Our Ref: 24/0302/TTCA
Your Ref: Tree prune

South Cambridgeshire District Council
Application for Works to Trees in a Conservation Area

Proposal: The tree is a Grey Poplar, and this application is to prune the tree by c.20% in order to prevent unwanted wind damage and any branches falling into the property's garden and neighbouring gardens. Additionally it's close to a neighbour's house (37 David Bull Way). I believe the conservation area was set up prior to the tree being planted as years ago Elm trees used to grow in just outside of the garden (prior to the estate being built in David Bull Way), otherwise the area is various residential gardens. A separate enquiry has been sent on this matter.

Site address: 25 Willow Crescent Milton Cambridgeshire CB24 6BY

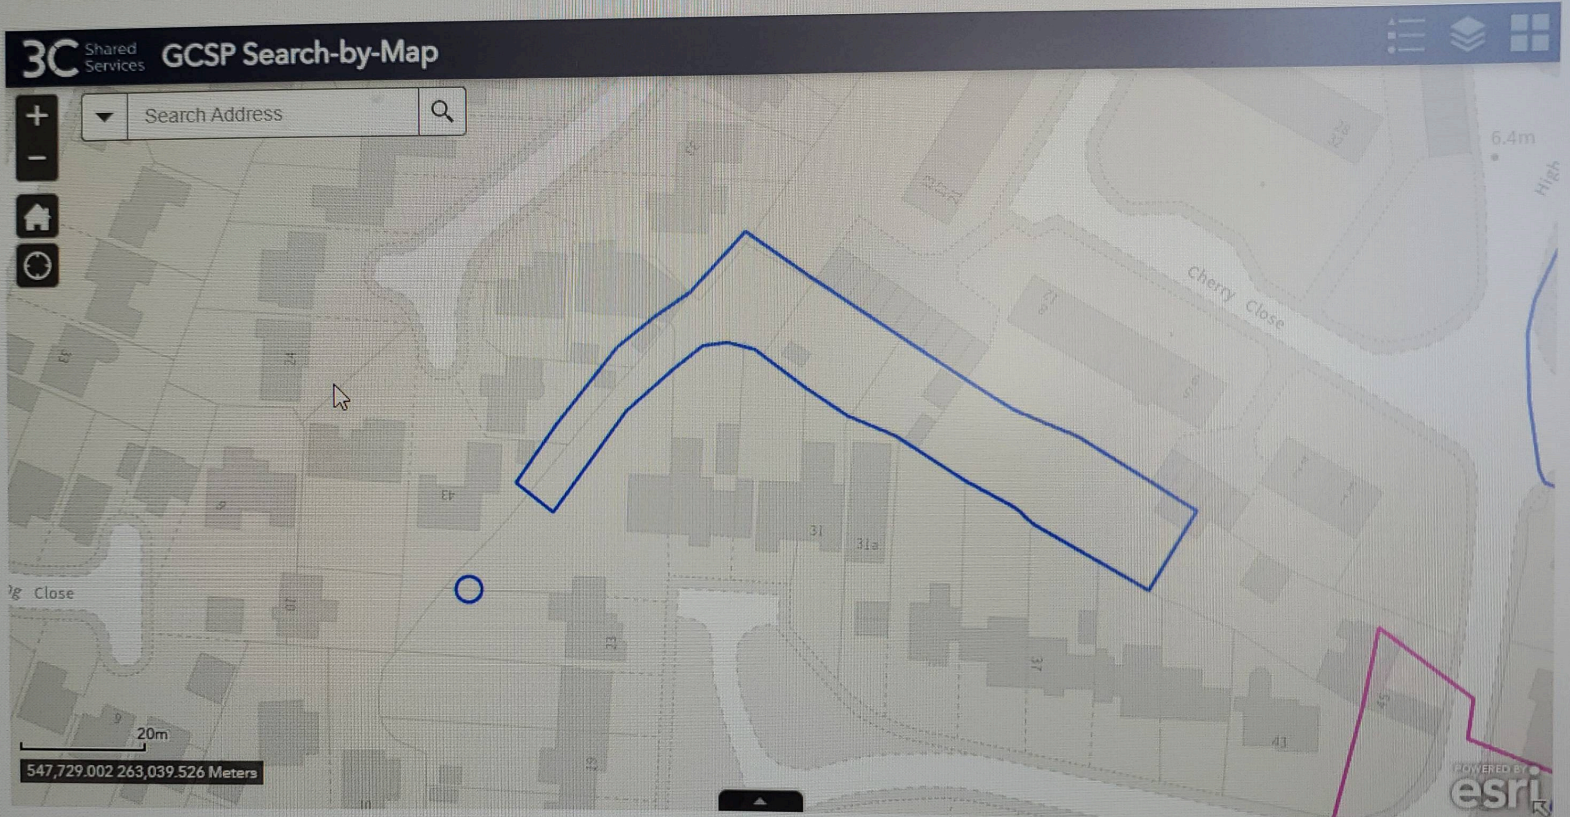
1. Please resubmit the Tree Site Plan highlighting exactly where the Poplar is located.
2. Please provide a clear description of works, including a measurement of the extent in metres.

e.g - Poplar, crown reduce height by Xm and width of Xm.
